Application No: EP/148/19/PL

Recommendation Report for Planning Permission

LOCATION: Scorton
9 Lime Tree Close
East Preston
BN16 1JA

PROPOSAL: Application for variation of condition no.2 imposed on planning permission EP/52/18/PL relating to amended internal layout & external appearance of plots 4, 5, 6 & 7 and alterations to external layout and landscaping.

Drawing ref: LTC.PLOT4.006

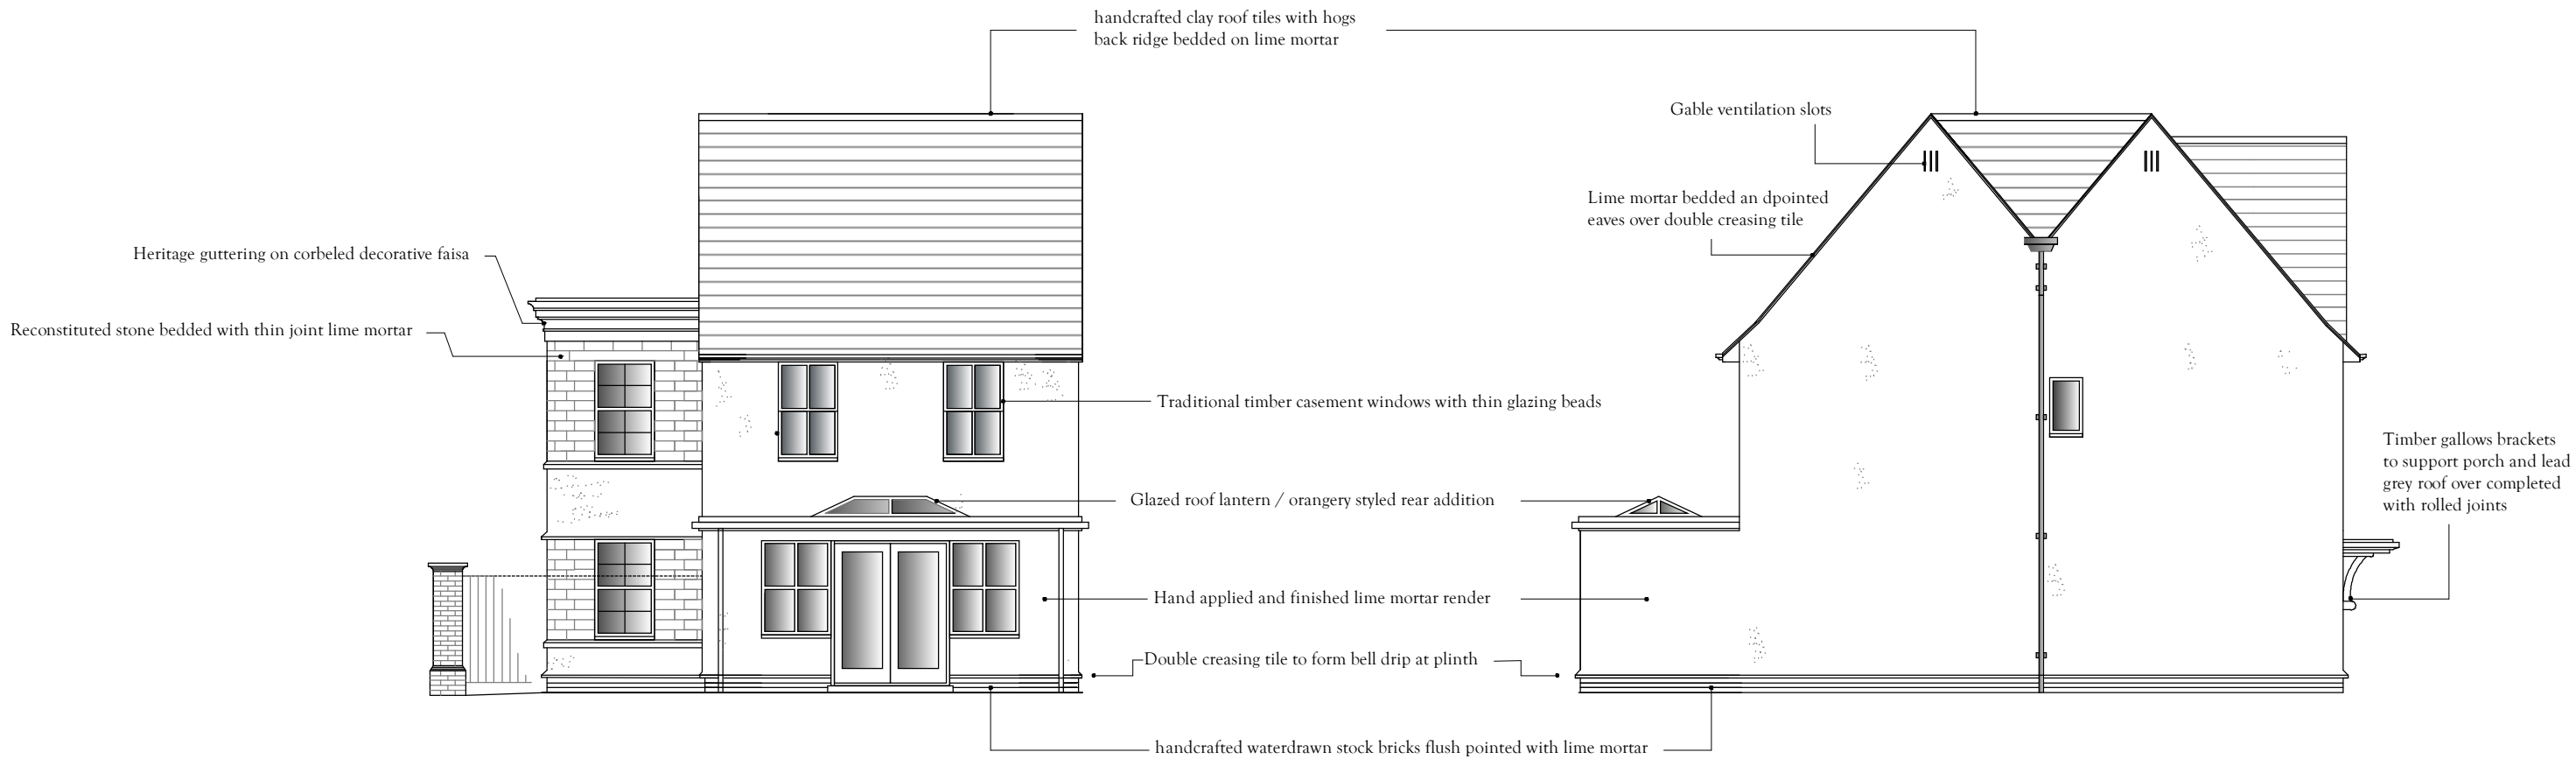
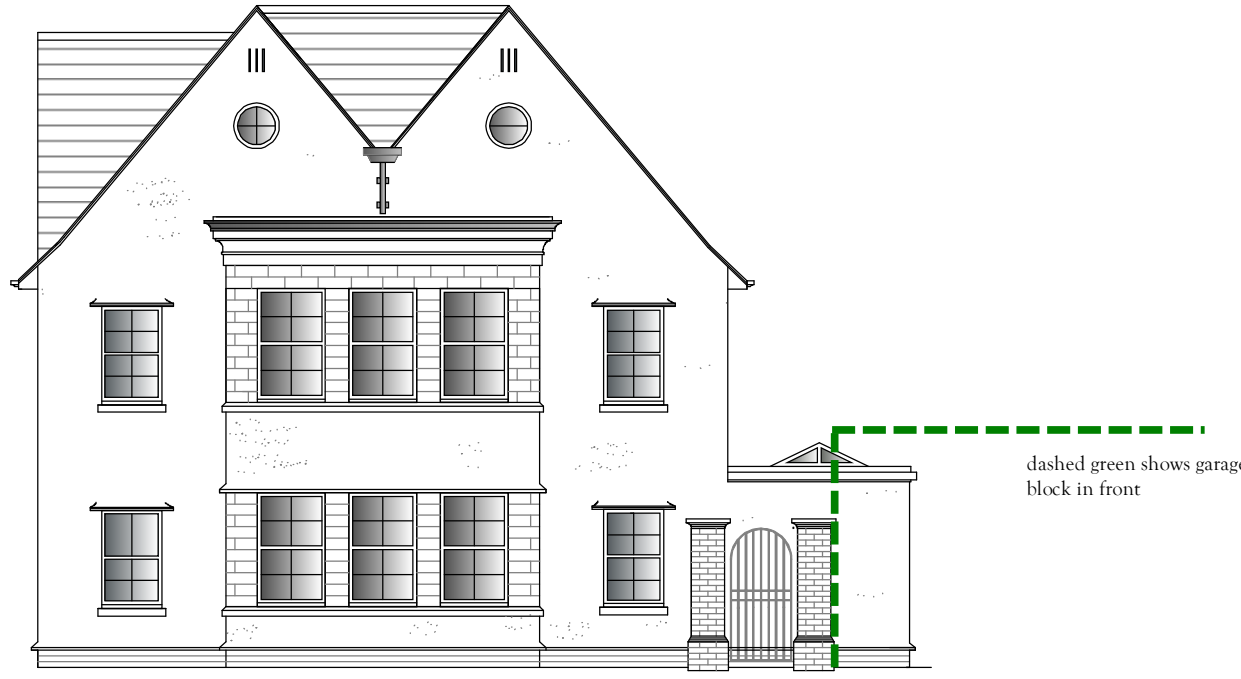
The proposed second floor windows on the south elevations of plots 4-7 are small, proportionate high level circular windows serving the staircase that would have no detrimental impacts on the appearance of the proposed dwellings. The proposed second floor windows on the west elevations of plots 4 and 7 are sympathetic in size and design to the remainder of their respective dwellings. The skylights within the roof of plots 4 and 7 would not be visible from the streetscene due to the roof design.

The units to the rear have 12 metres to the boundary and 21m between properties. None of the proposed windows would have any impacts on the privacy available to the proposed or existing properties. The proposed second floor windows on the south side of Plot 4 are over 30 metres from the nearest property to the south. The proposed second floor windows on the south side of Plots 5, 6 and 7 would look onto the predominantly blank northern elevations of the proposed adjacent properties. The proposed new windows on the west elevations of Plots 4-7 will have no greater impact on the privacy of Plots 1-3 than the existing approved first floor windows. These distances are adequate to prevent any materially adverse overbearing or overlooking resulting. The proposal therefore accords with policy D DM1(3) of Arun Local Plan.

Drawing ref: LTC.PLOT5&6.006

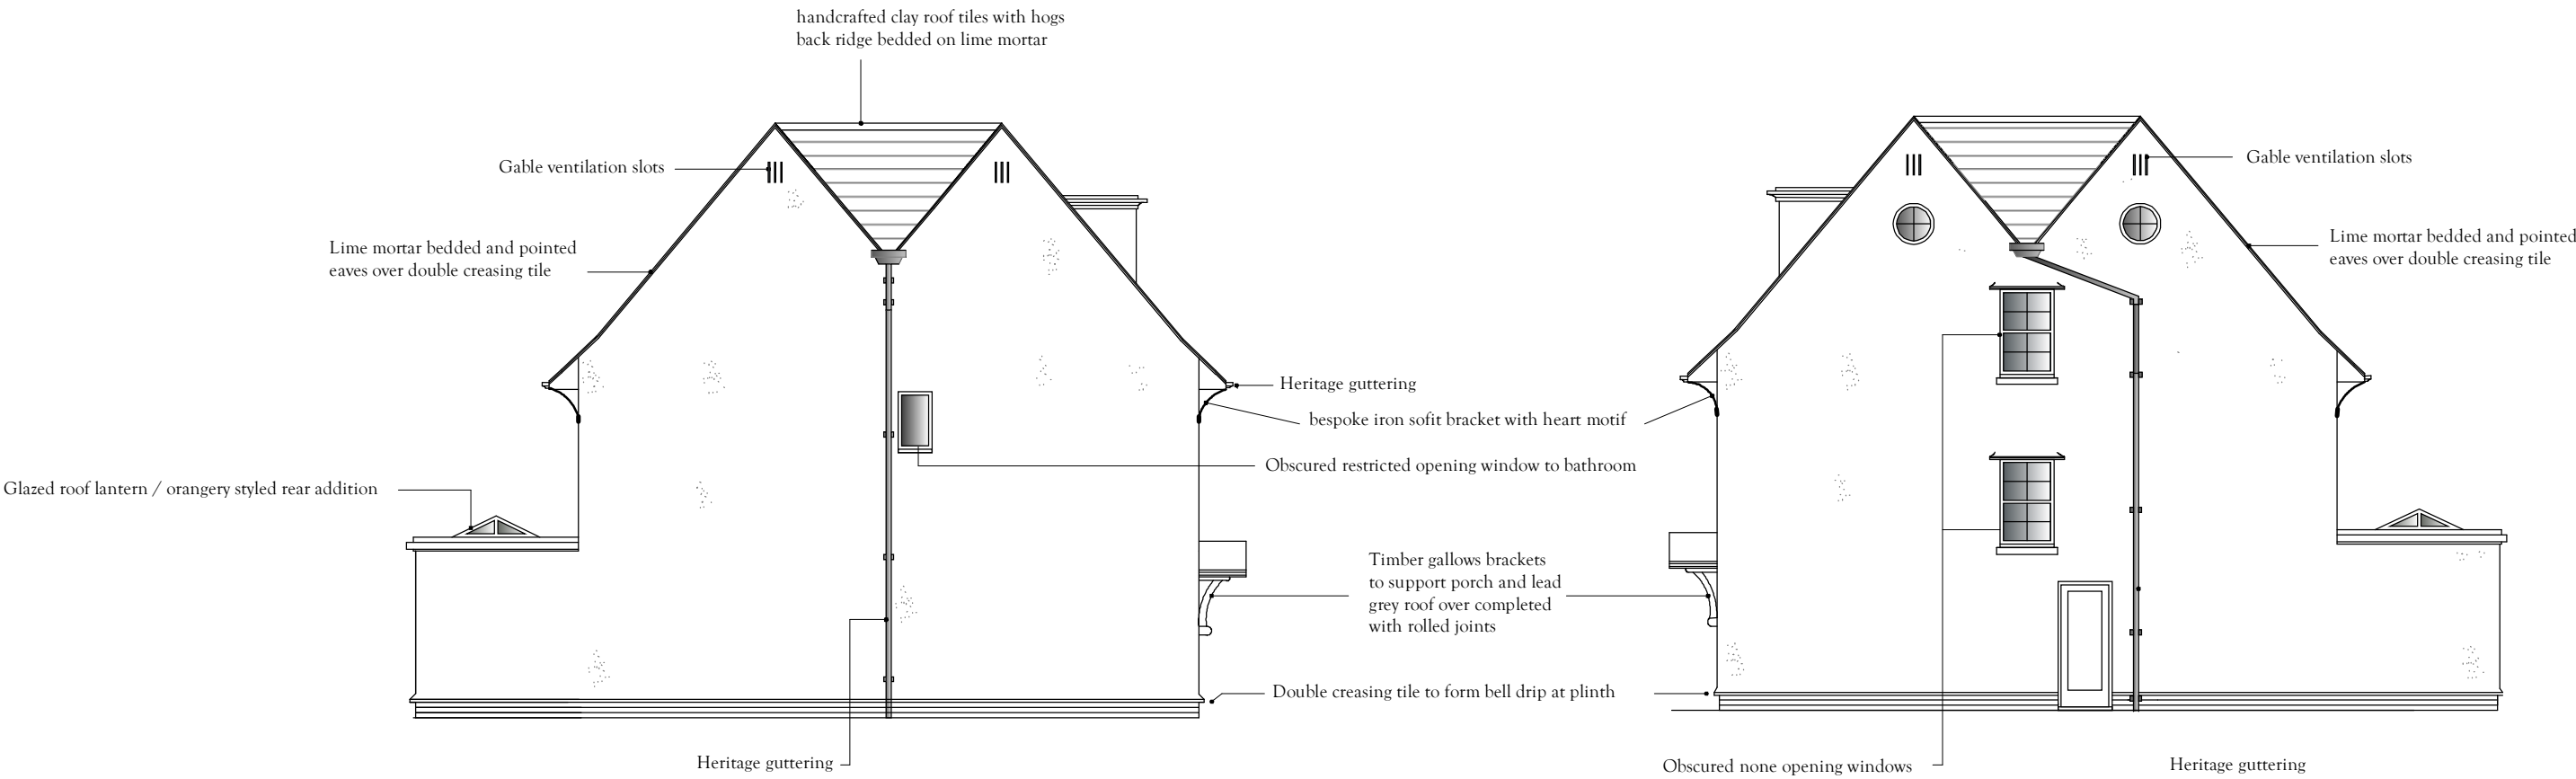
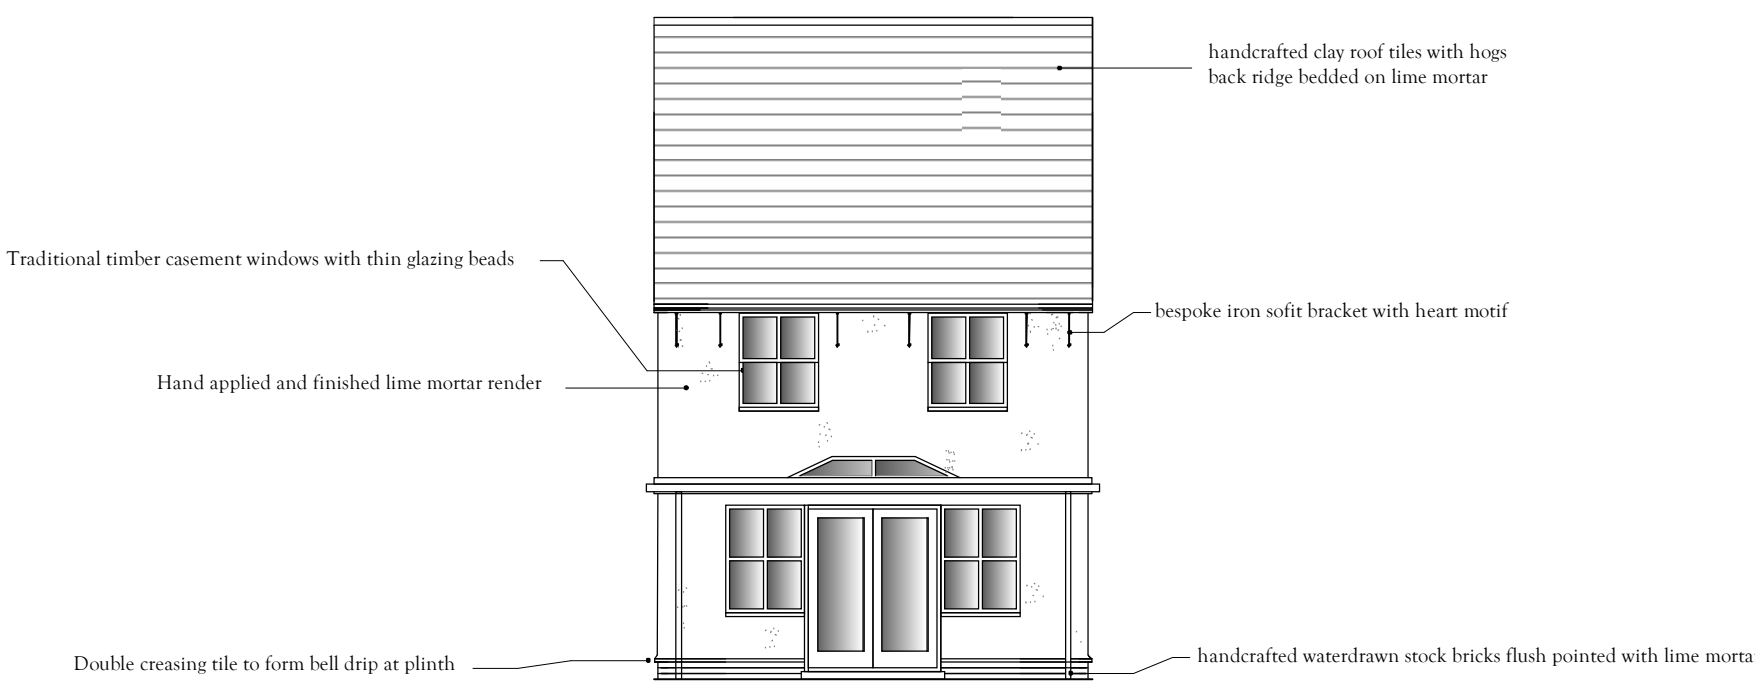
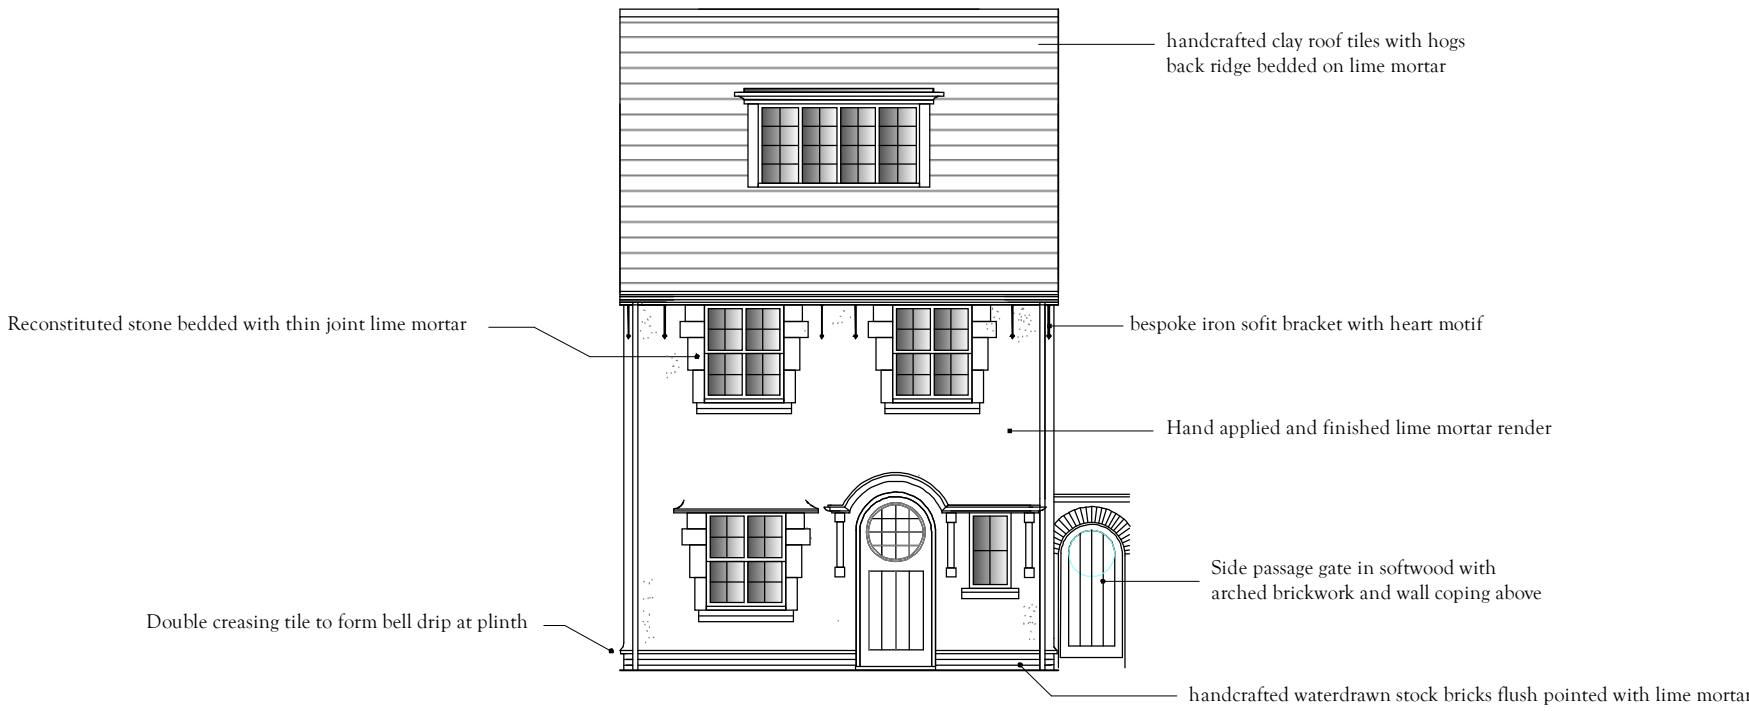
The proposed dormer windows on the (front) west elevation of plots 5 and 6 are of a modest scale and do not dominate the roofscape. As a result, they would not have any material impact on the wider streetscene and would accord with Arun Local Plan policies D DM1 and D SP1 and Policies 1(i) and 4(i) of East Preston Neighbourhood Plan. The provision of a footpath to the development would only be used for access by residents and would not be visually obtrusive or look out of place in the street scene.
